CITY OF ALBUQUERQUE  
ADMINISTRATIVE APPROVAL (AA)- SITE DEV PLAN AMENDMENT  
REVIEW SHEET

APPLICATION #: 11AA 10018	PROJECT #: 1002836
PROJECT NAME: Lead Ave	
APPLICANT or AGENT: The Hilltop Landscape	
PHONE # and E-MAIL: 898-9690	
ZONE ATLAS PAGE: K-15	
ADMINISTRATIVE APPROVAL (AA) for: EPC CASE DRB CASE

Re: Jarvis Law Office AA for Landscaping Plan

A1 SITE PLAN

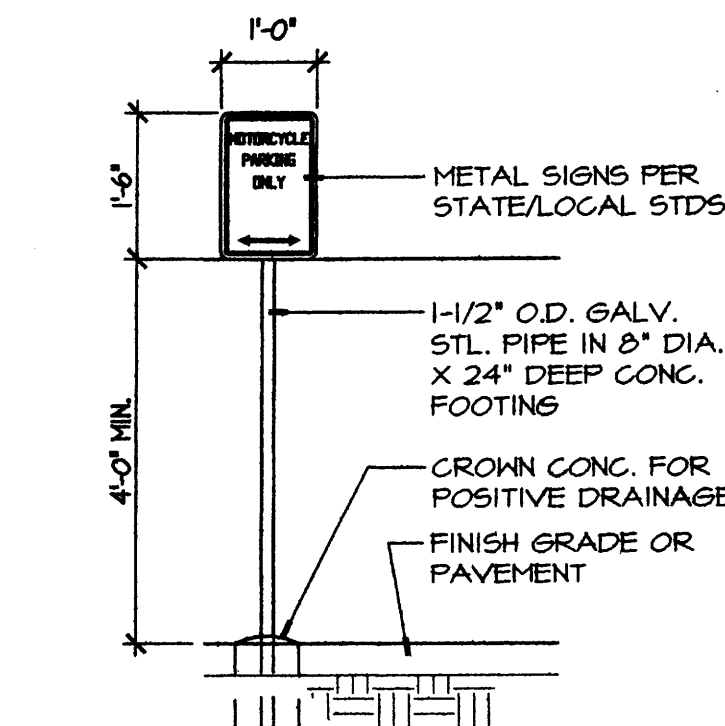
PLANS DISAPPROVED:	DATE: <del>2-17-11</del>	DATE:
PLANS APPROVED:	DATE: 2-17-11	DATE:
COMMENTS: provide a plan that shows what Lead Ave will look like <del>as a CIP project (2 sht), provide conceptual Grading and Drainage Plan. CC 2-17-11</del>

PLANS DISAPPROVED:	DATE: 02-17-11 / 02-22-11	DATE:
PLANS APPROVED:	DATE: <del>02-14-11</del>	DATE:
COMMENTS: Call Kristal Metro at 924-3991 This site had previously been submitted as a TCL, and does not match the proposed layout. -parking must be paved		
02-22-11 layout must match approved layout (provided) <del>and</del> previously approved TCL has been revised; parking stalls must be paved; drainage structures must be shown; parking is proposed, not existing; contact Kristal Metro @ 924-3991
